Tuesday 19th May 2020

Sir Antony Gormley submission for Deadline 6

2.0.8 – Gantry Design

2.5.1.a – Landscape mitigation

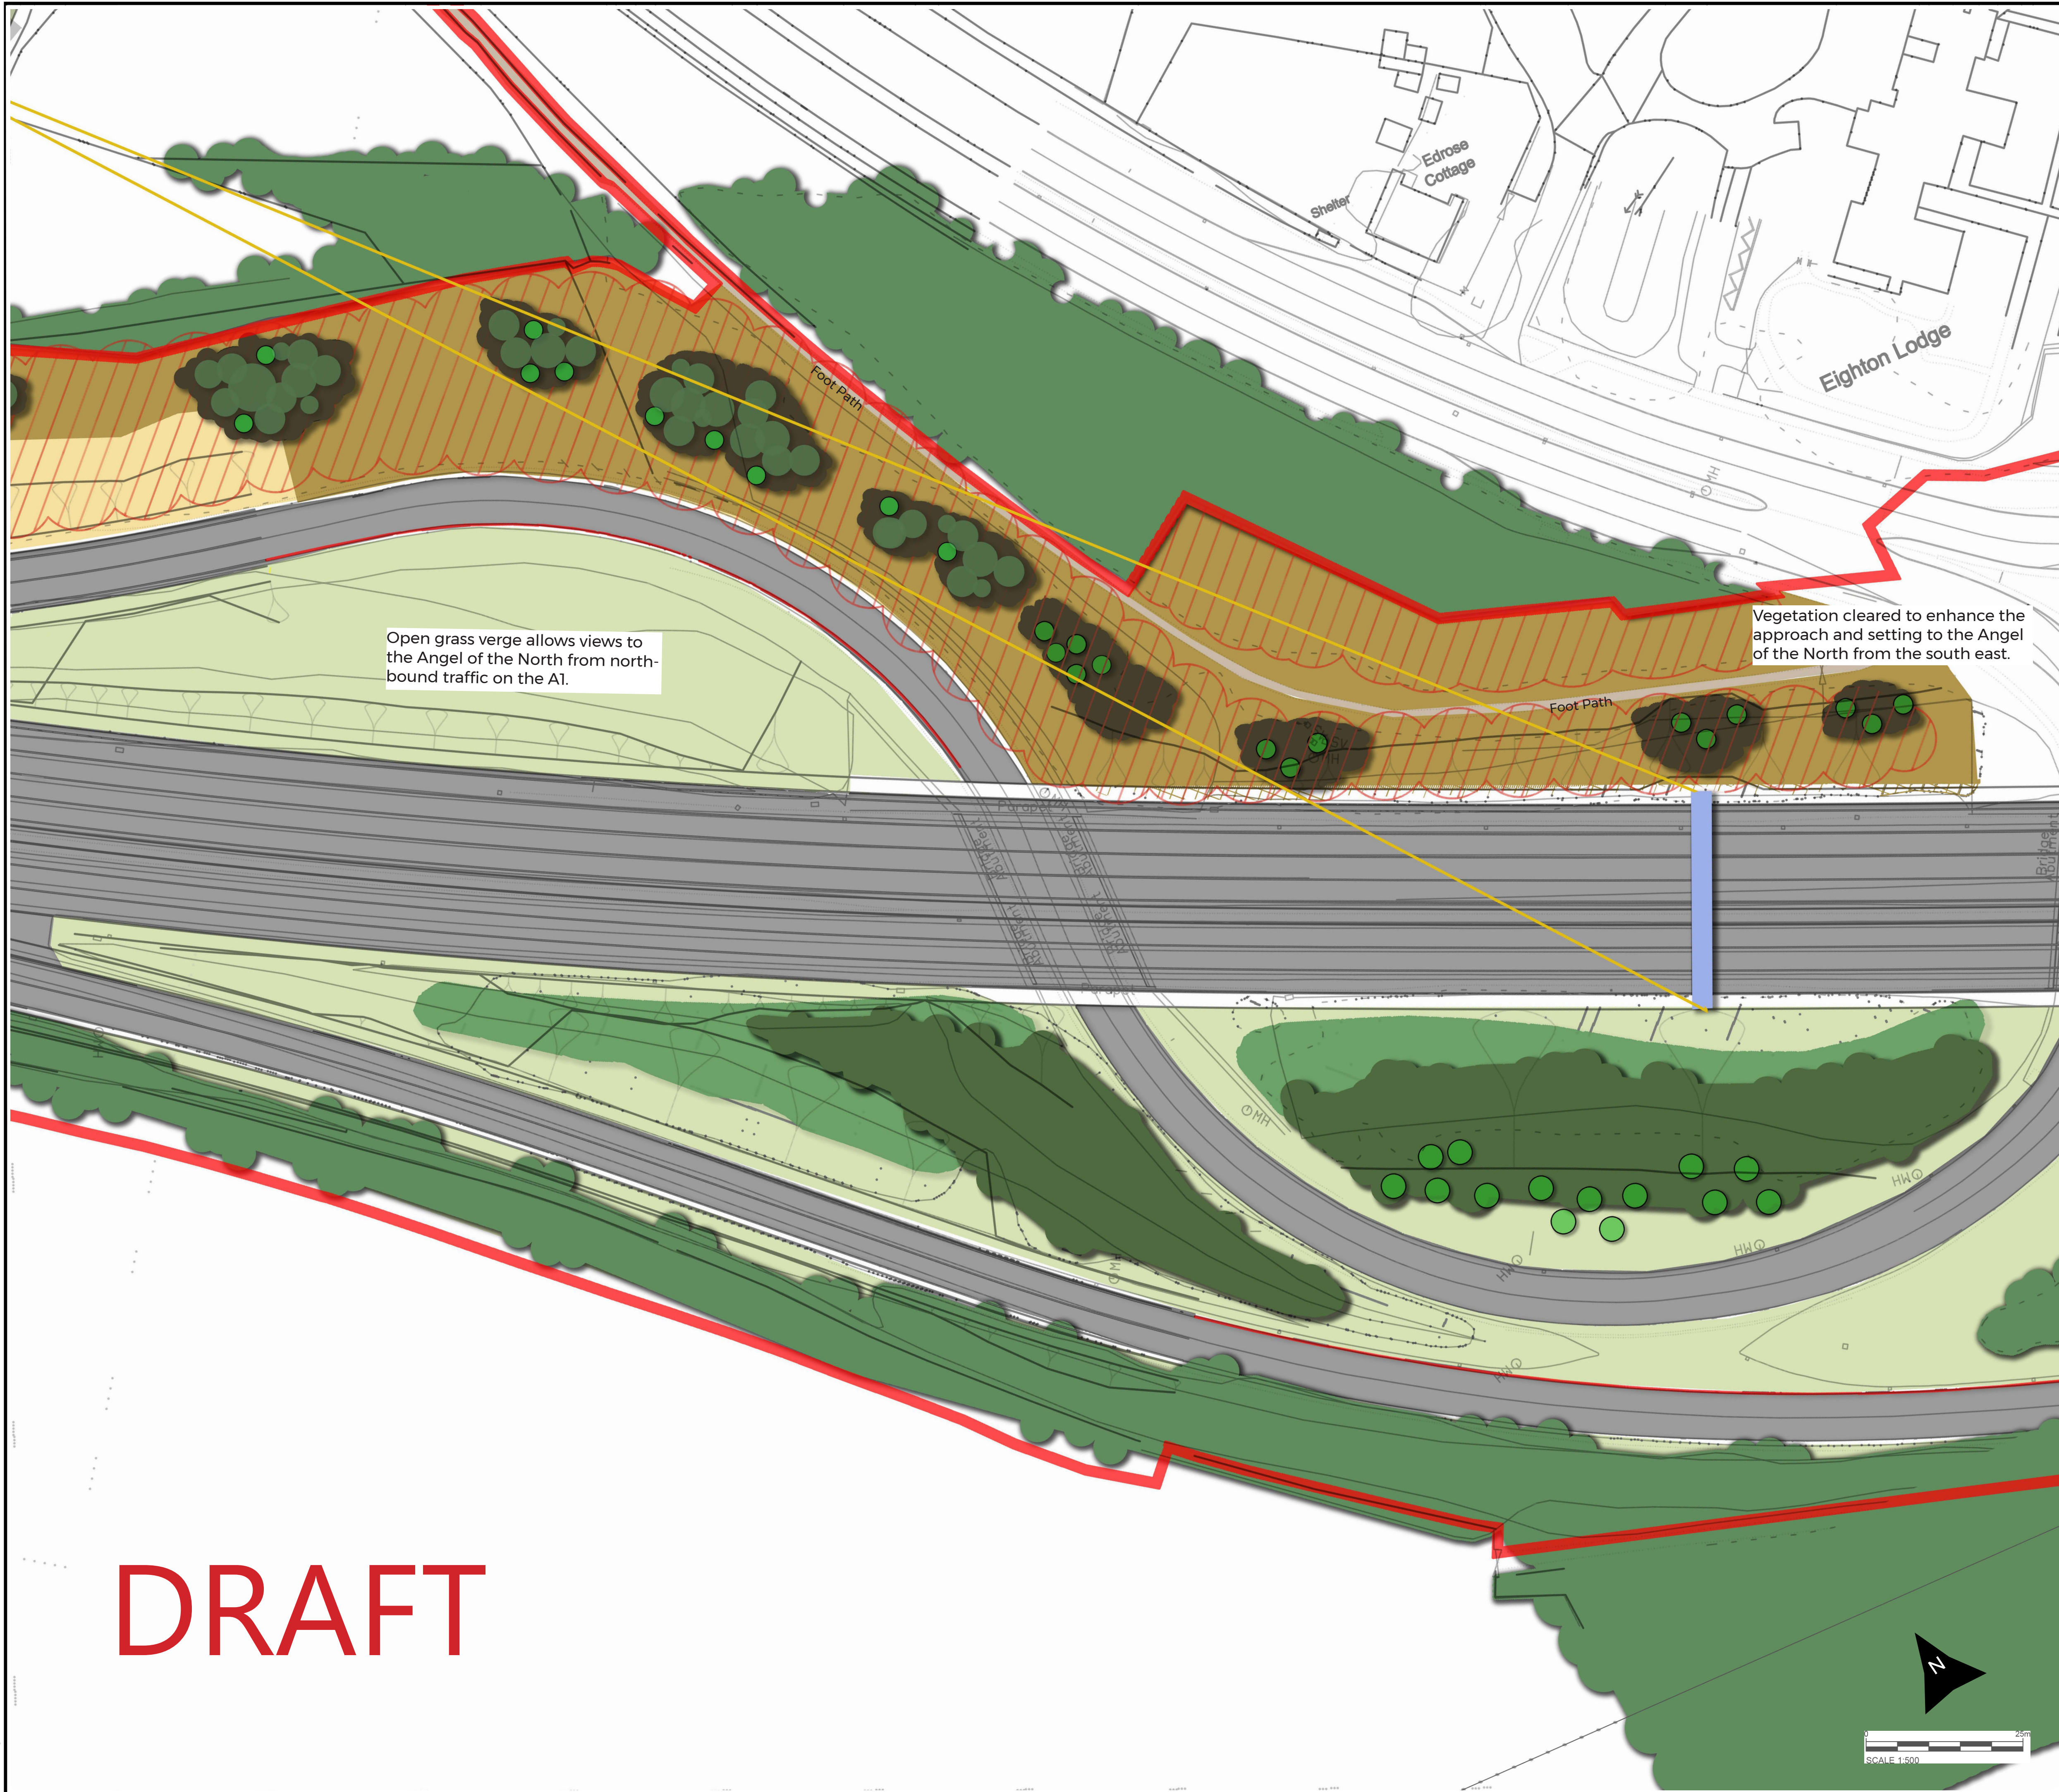
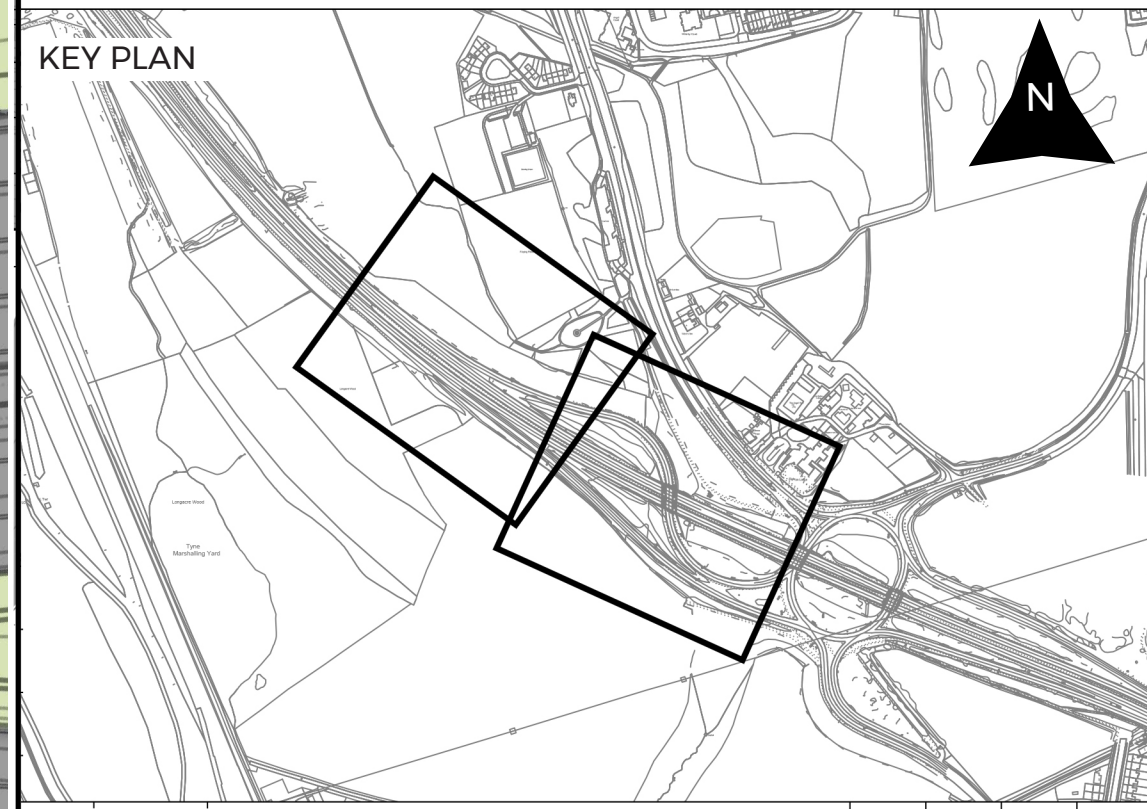
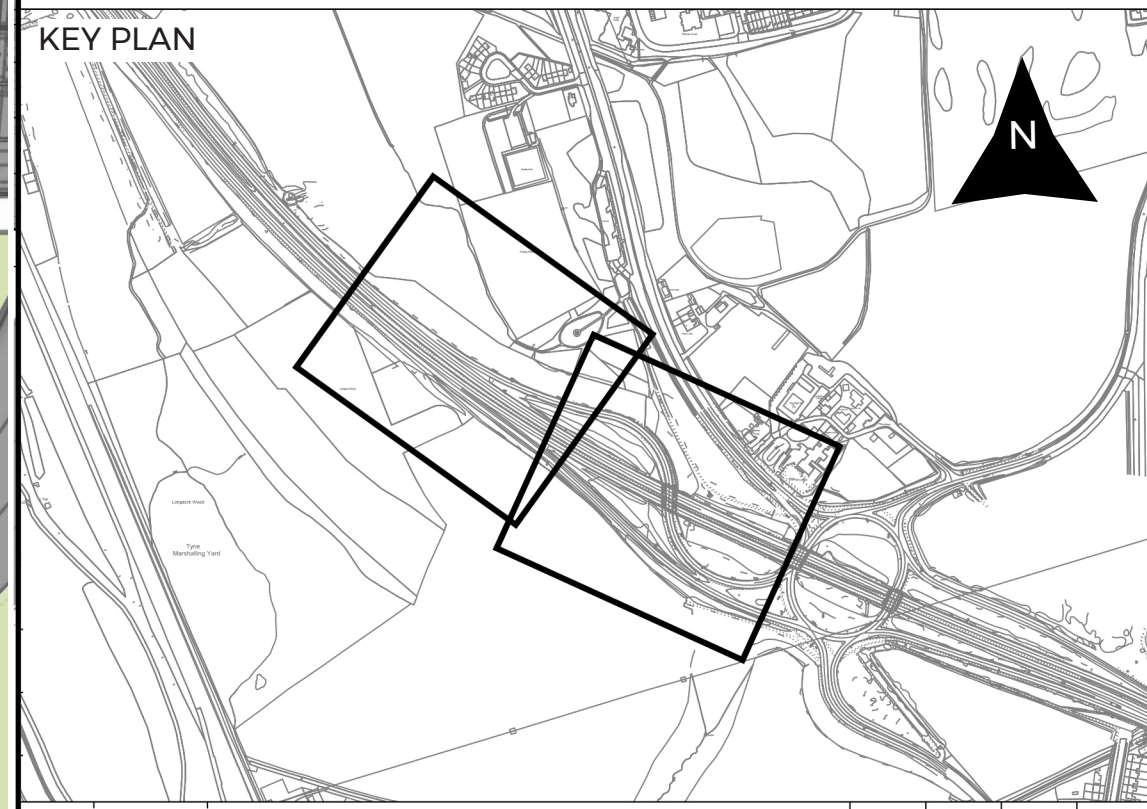
The design seems to show the planting of low scrubs and clearing of vegetation to open up various sight lines to the Angel of the North and depicts these sight lines (marked in yellow) in relation to the gantries (marked in blue) in closest proximity to the Angel of the North.

Again, all assessments have been made based on current vegetation cover as the baseline and the Applicant has stated that they will not consider undertaking any further analysis. We would like further reassurance that the vegetation on the embankments in the nearby vicinity to the Angel of the North consists of low-lying shrubbery. To mitigate against the negative impacts of the scheme, and to return the views of the Angel of the North to their former state, we would ask that the surrounding vegetation remains below the skyline so that the Angel of the North and the mound are clearly visible.

Crucially the site lines depicted are *from* the Angel of the North rather than site lines from vehicles on the A1 *towards* the Angel of the North. We are most concerned by the negative impact of the scheme on views for A1 users, and again would argue that *TRO10031-000988-Appendix 1A* does not go far enough to illustrate the disruption of views for road users.

The proximity of the Eighton Lodge gantry to the Angel of the North is most worrying. We would ask that the Applicant considers moving the Eighton Lodge gantry to the South by 150m to minimise negative impacts on views in the immediate approach to the Angel of the North.
